WA/83/21/L

8 Walberton Park Walberton Arundel BN18 0PJ

Listed building consent to replace existing French doors with like for like and with heritage slim double glazing

Proposed: Cream Sashwood
Floor: 1st - 2nd Floor Cream, Ceiling
3. Sash Terrace / Verandah
Chapman, Darter, Darter
Scale: 1:1
Chapman, Darter, Darter

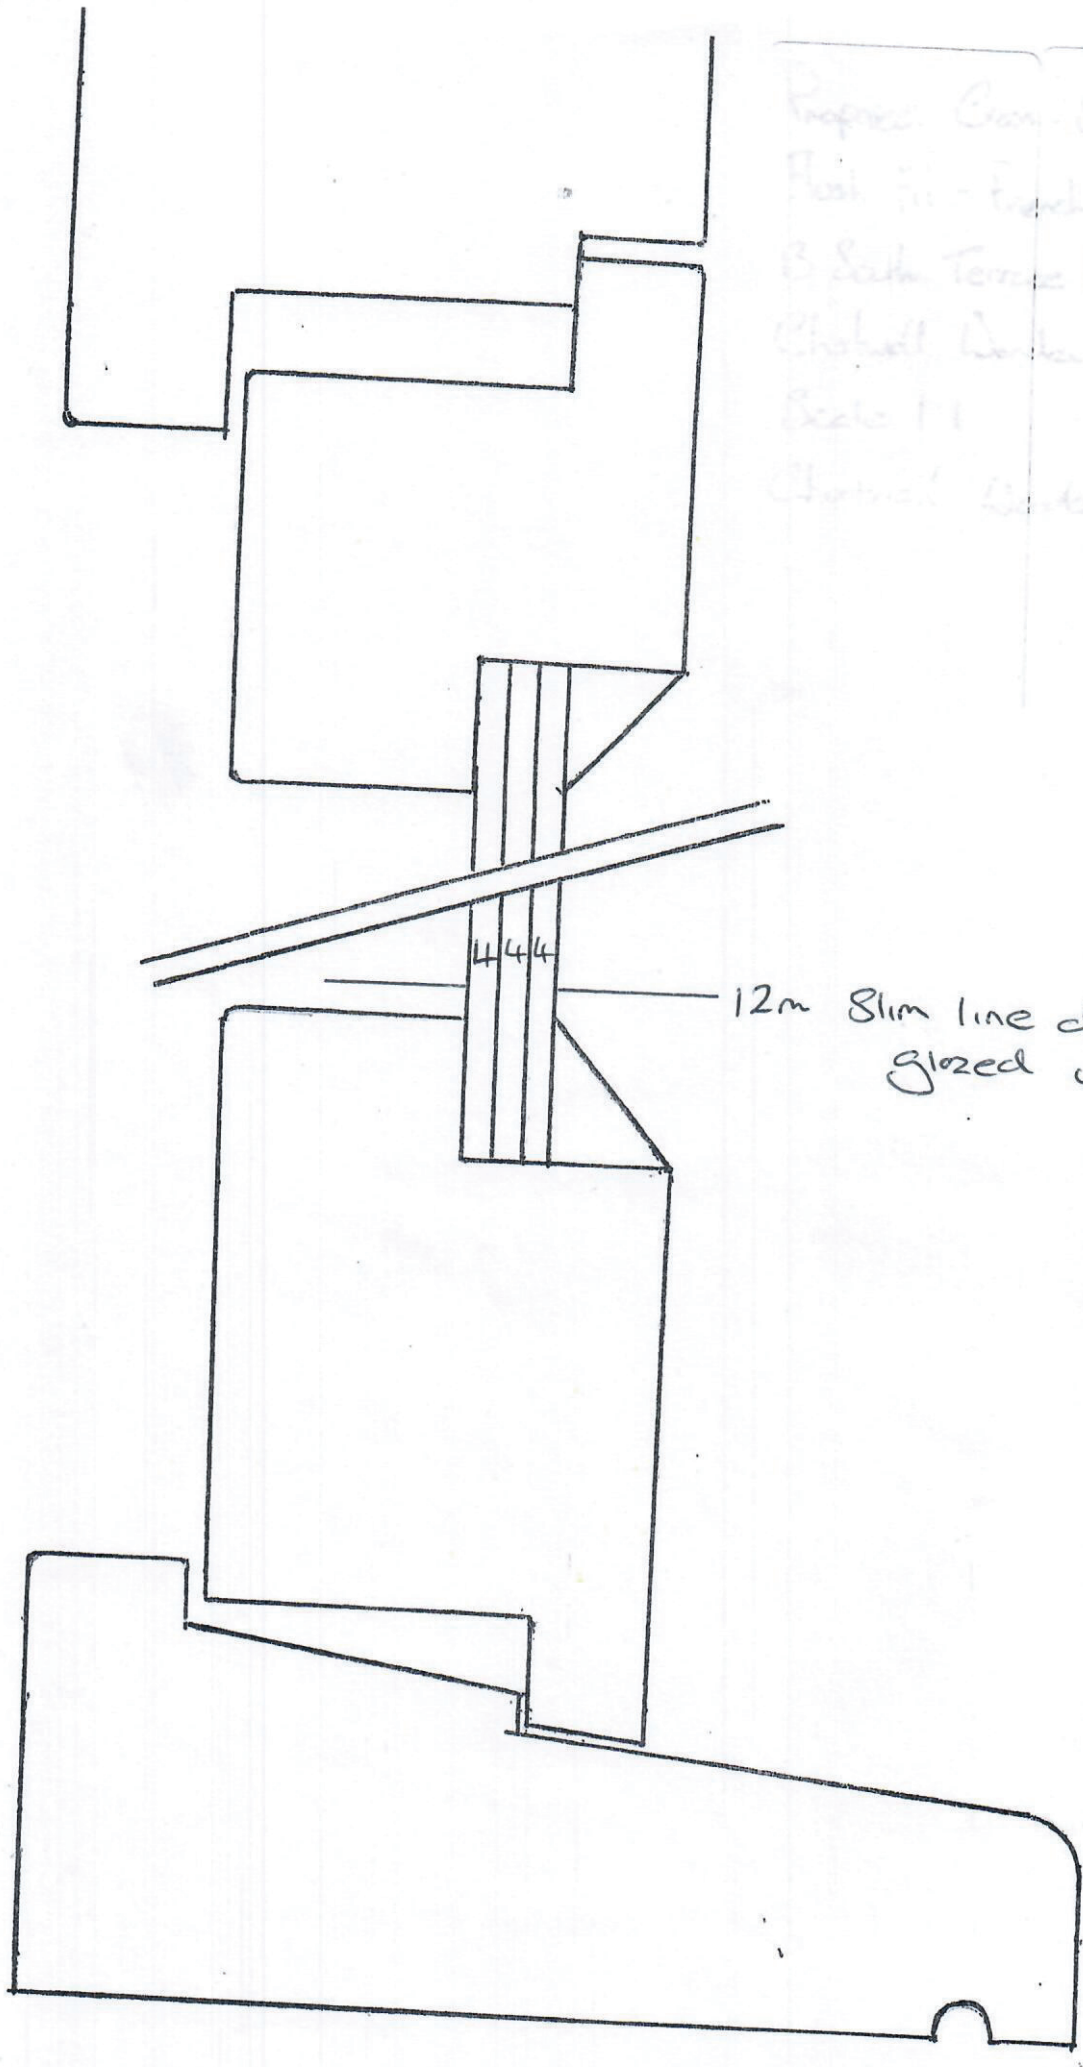
I would want to ensure that the glazing bars are integral to the French Window as opposed to applied to the glazing, and to be of an appropriate style. The latter not being appropriate

It is considered that as the French Window is of modern fabric in a modern late C.20 extension to the listed building, and some distance away from the main listed building, that this proposal is acceptable. This is subject to the confirmation of the use of appropriate glazing bars.
